Axtman Farms, Inc.
1100 Christensen Rd
Allensburg, WA 98926

Comments re: Brown and Jackson (SE 20-02203)

**BROWN & JACKSON**  
 Land Application Site  
 Preliminary  
 Site Map  
 Kittitas County  
 Washington

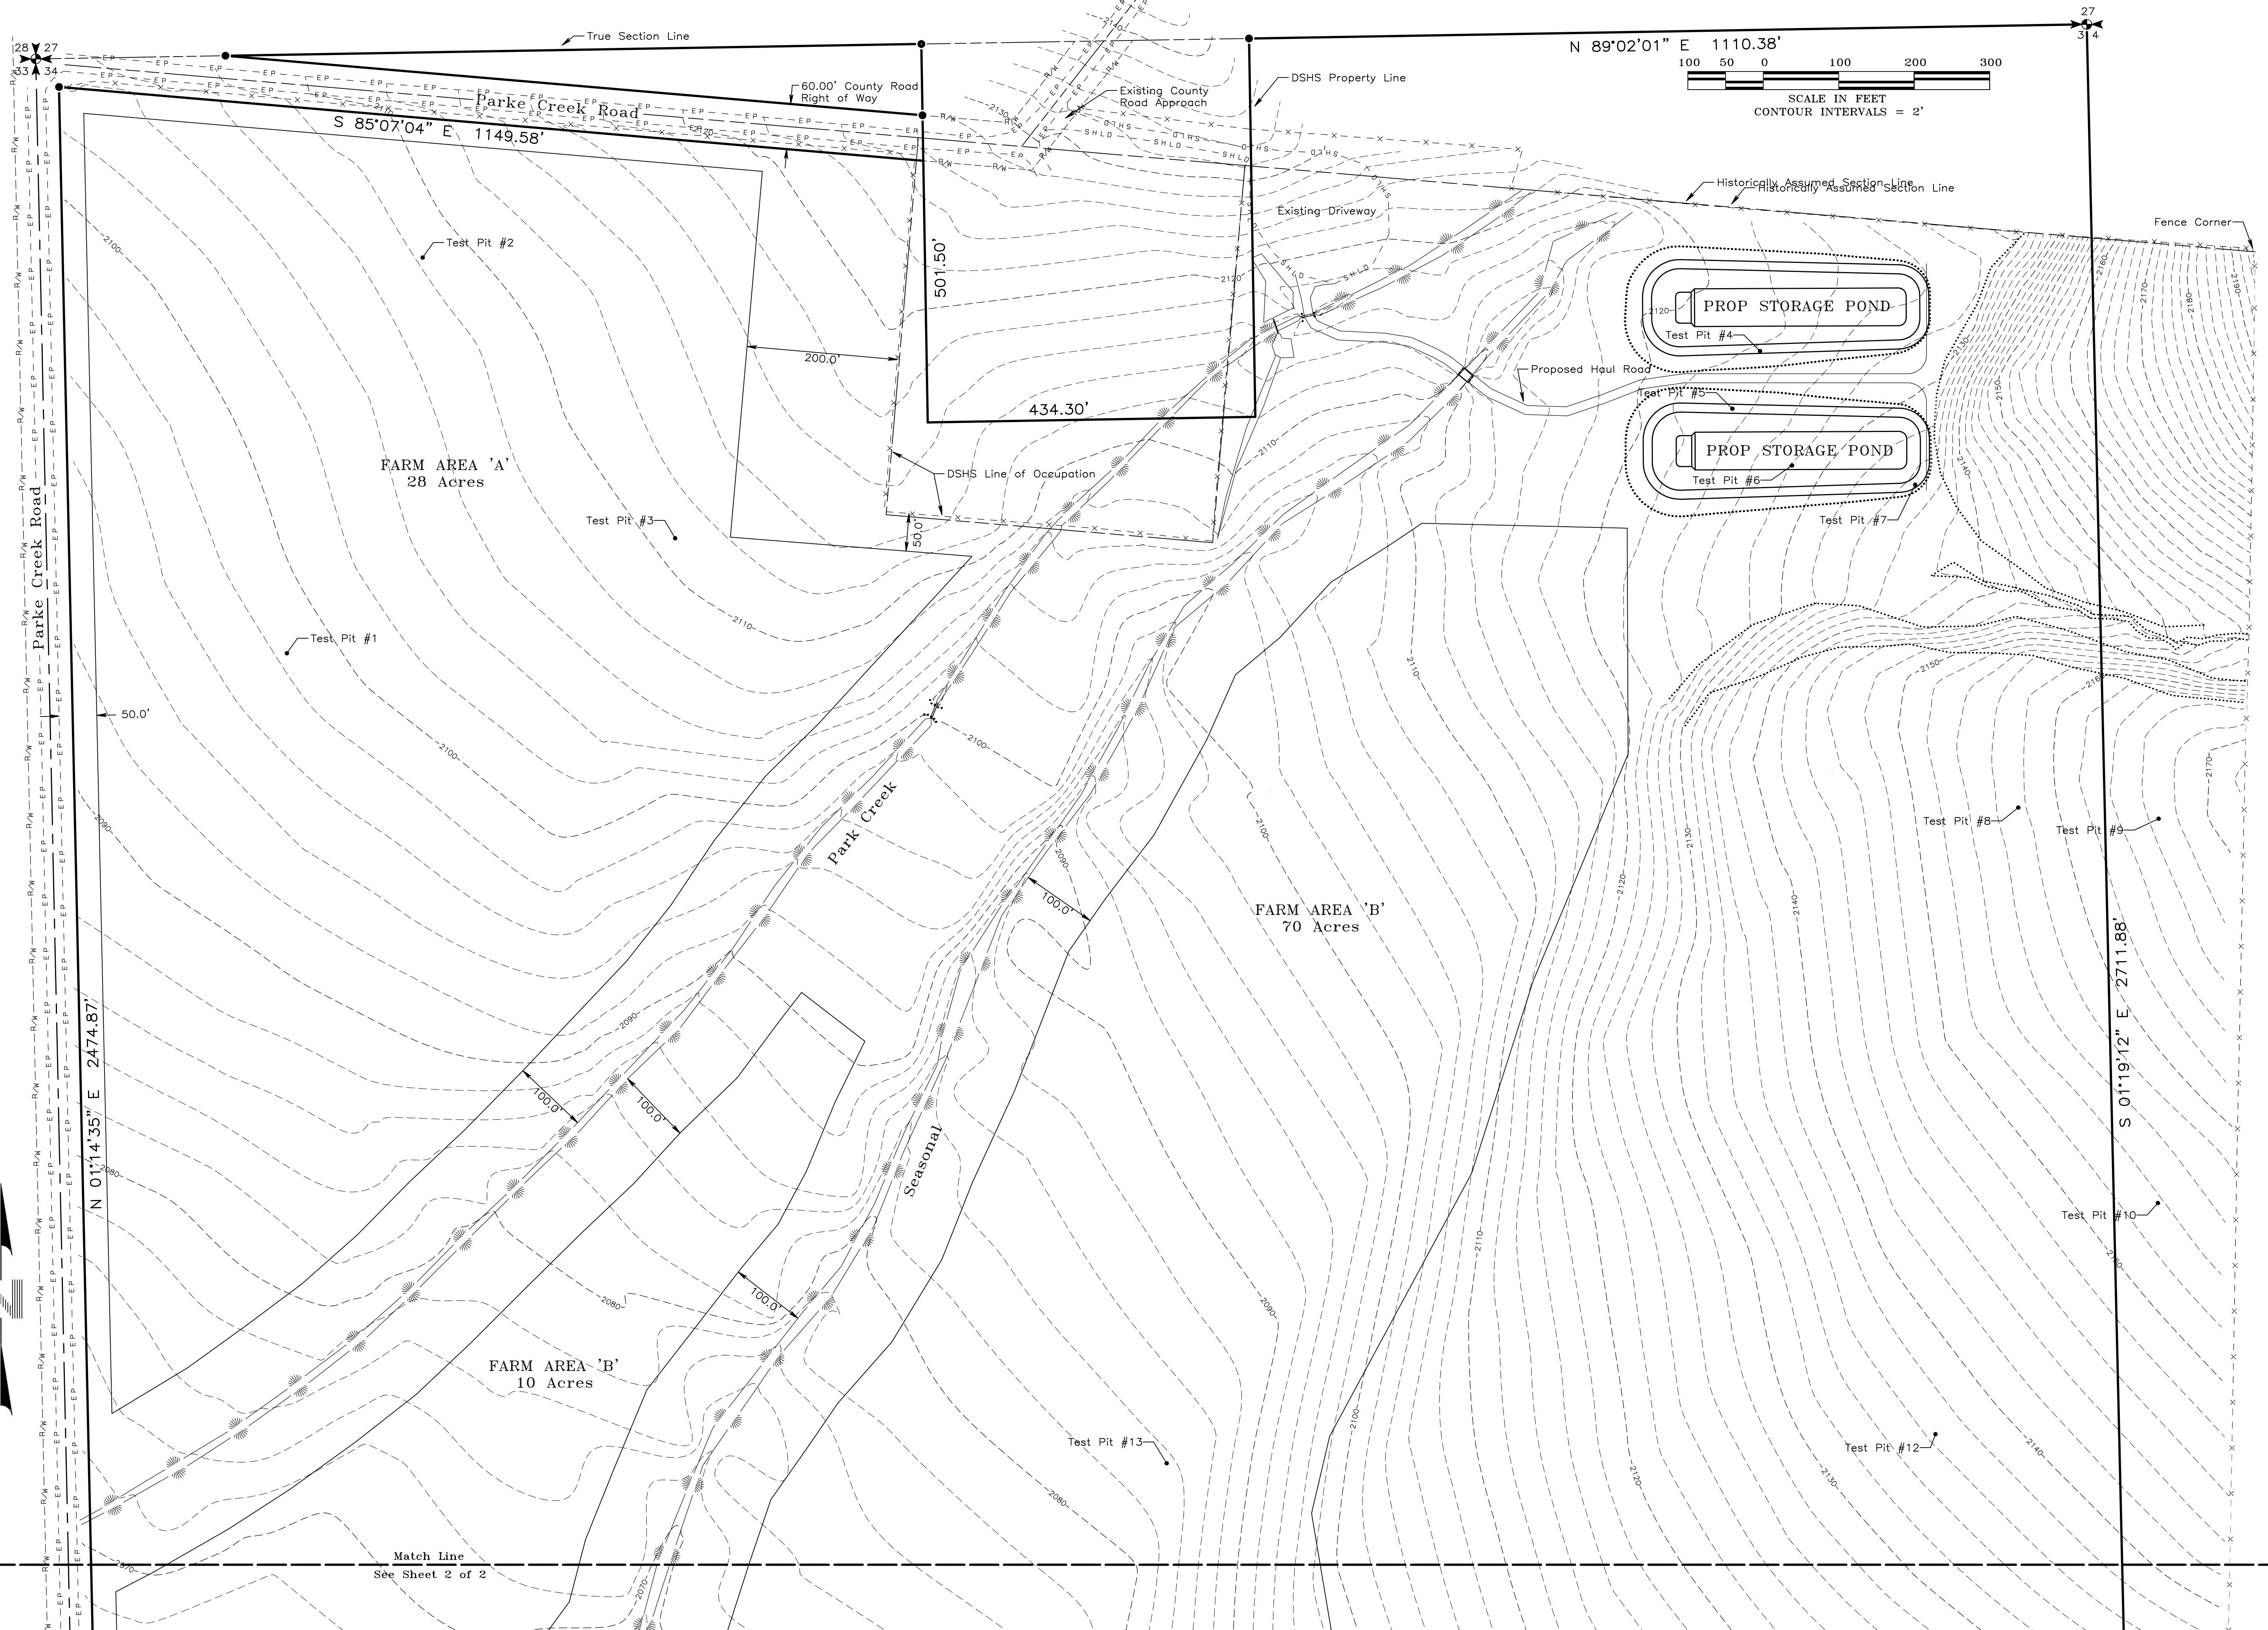
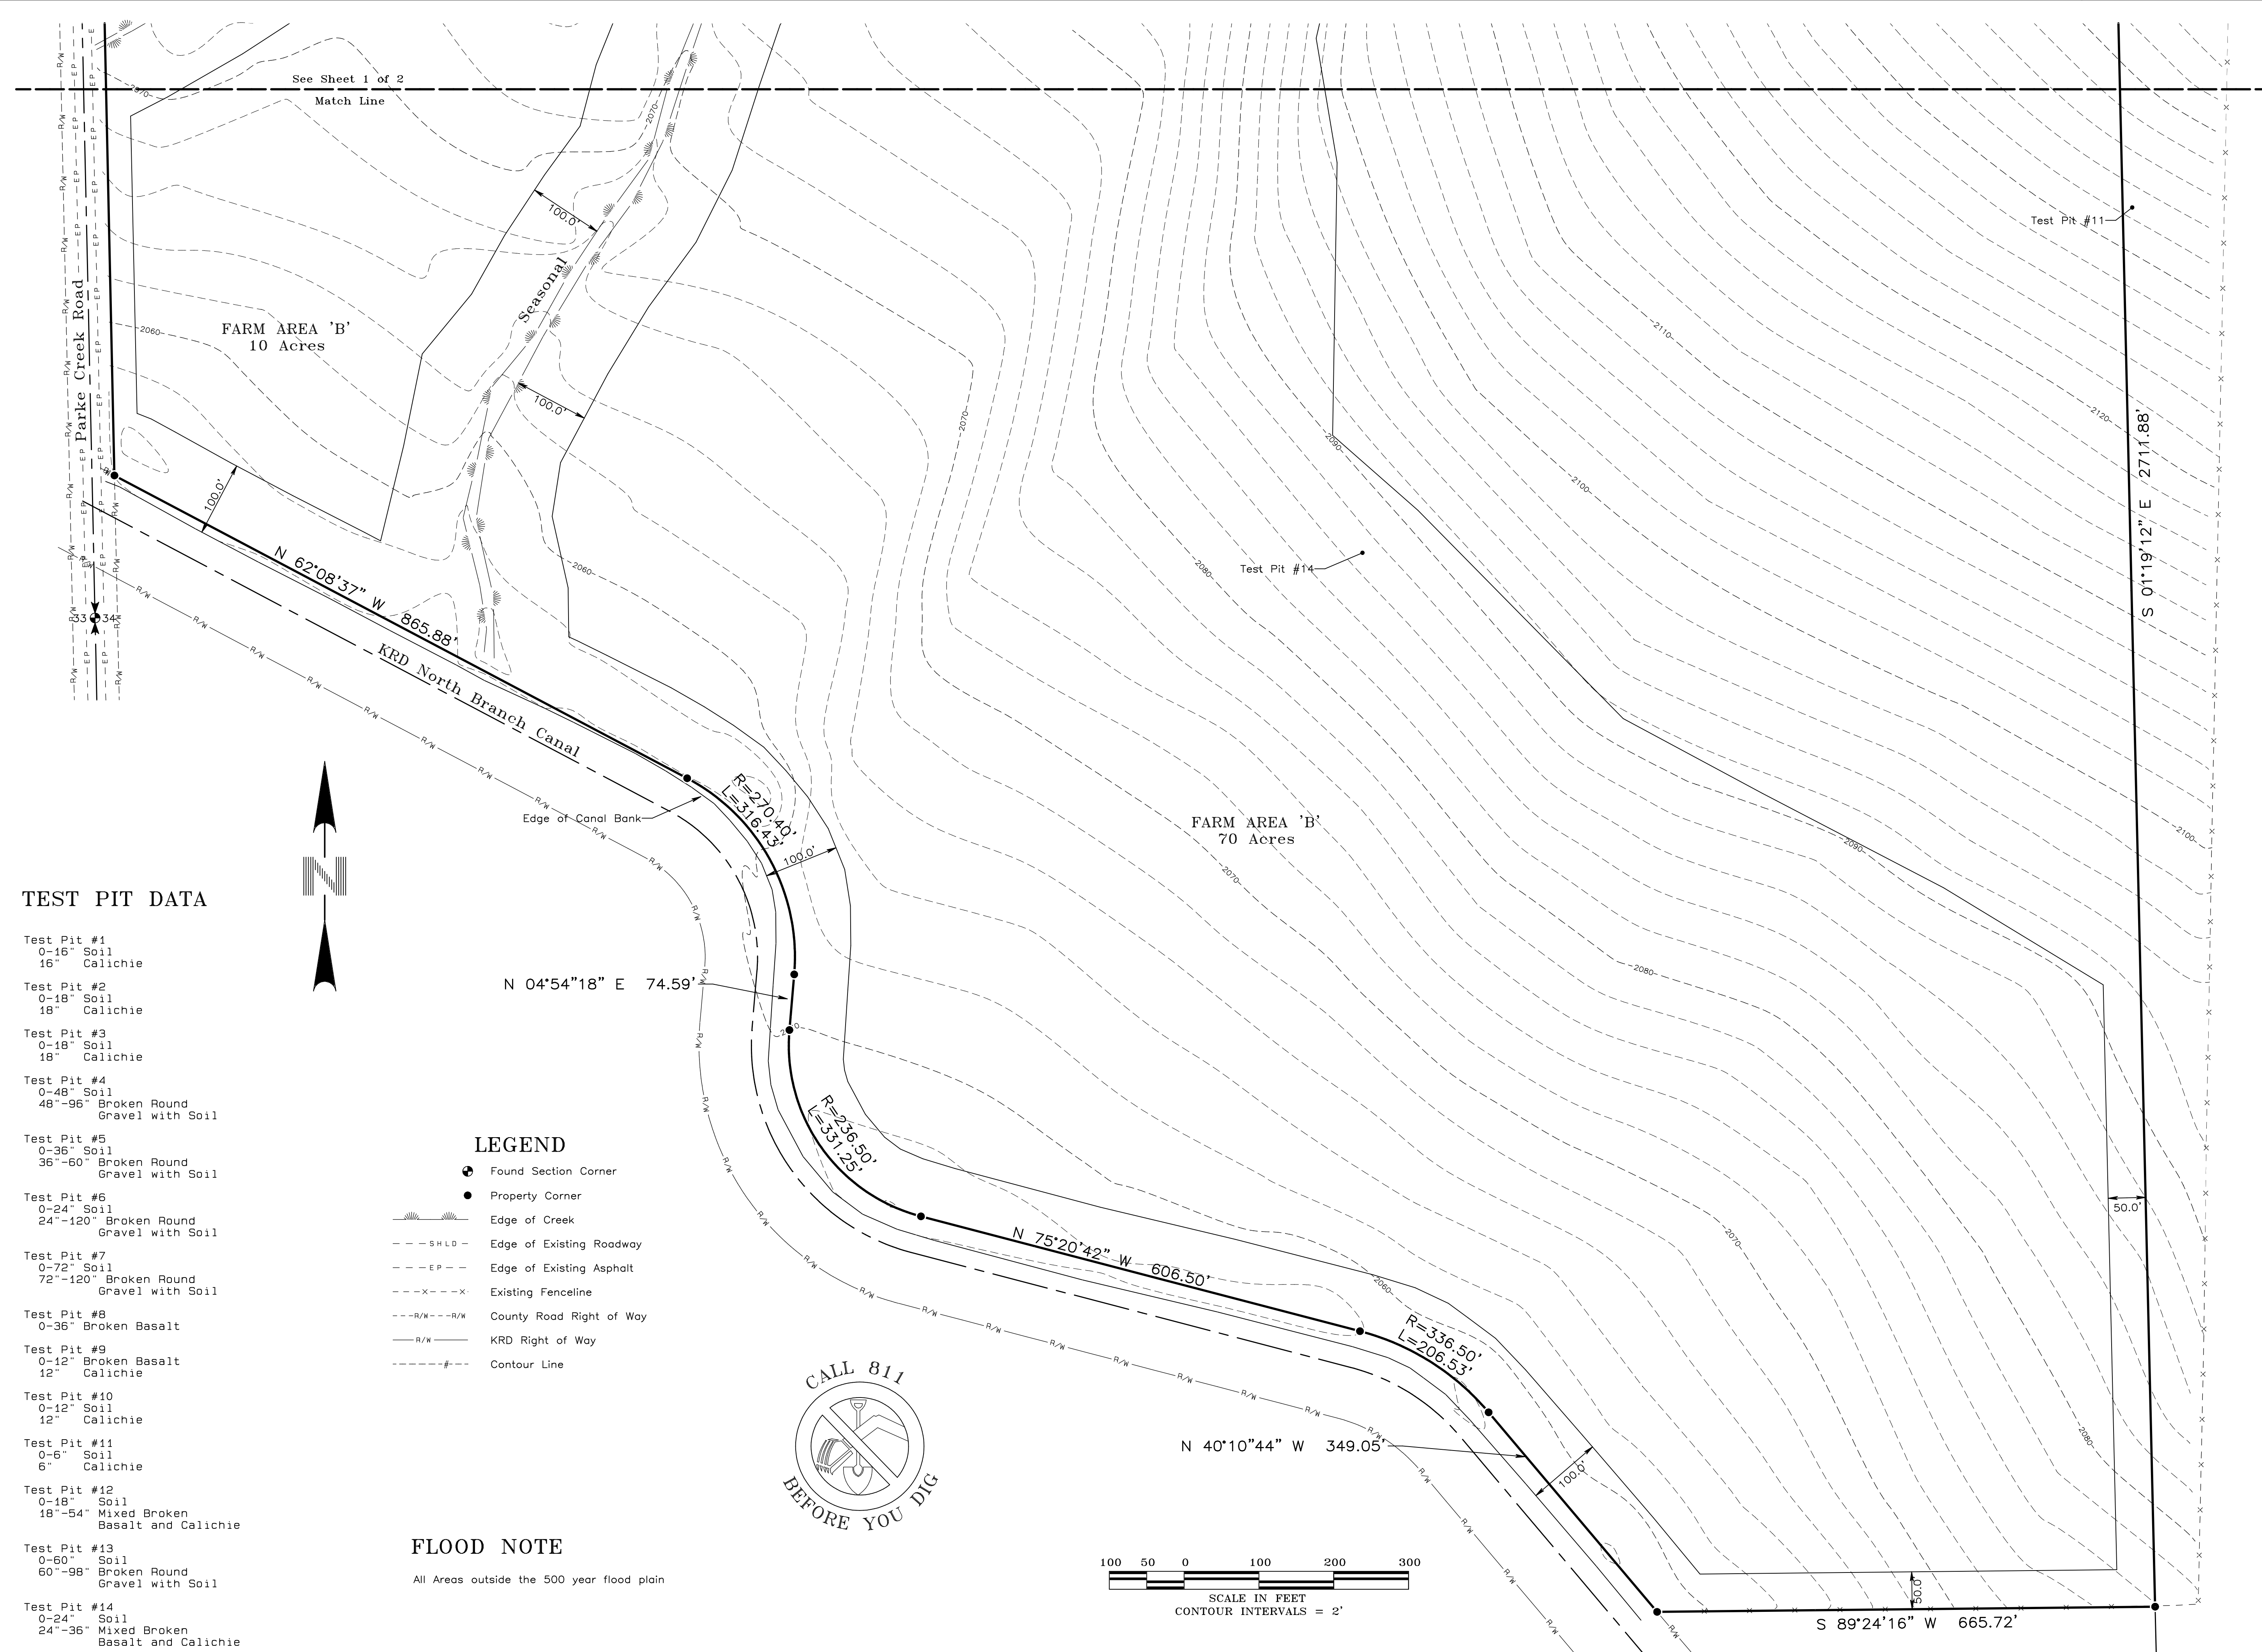
3. Possible contamination of Parke Creek and Parke Creek diversion, both of which flow through our property. Our livestock drink from the diversion. There are times when Parke Creek floods out onto our hayfield.

4. Possible contamination of the land. The soil here is very shallow and sits on a layer of coliche. What will happen after years of application of this sewage? What happens to all the non-fecal materials in the sewage such as feminine hygiene products, medications, chemicals and anything else people dump into their septic? If these are all spread onto the land, there are sure to be items that don't readily degrade, which the wind could carry all over the neighborhood and onto our hayfields. Besides being a litter problem, this would contaminate our hay and ruin its export value.
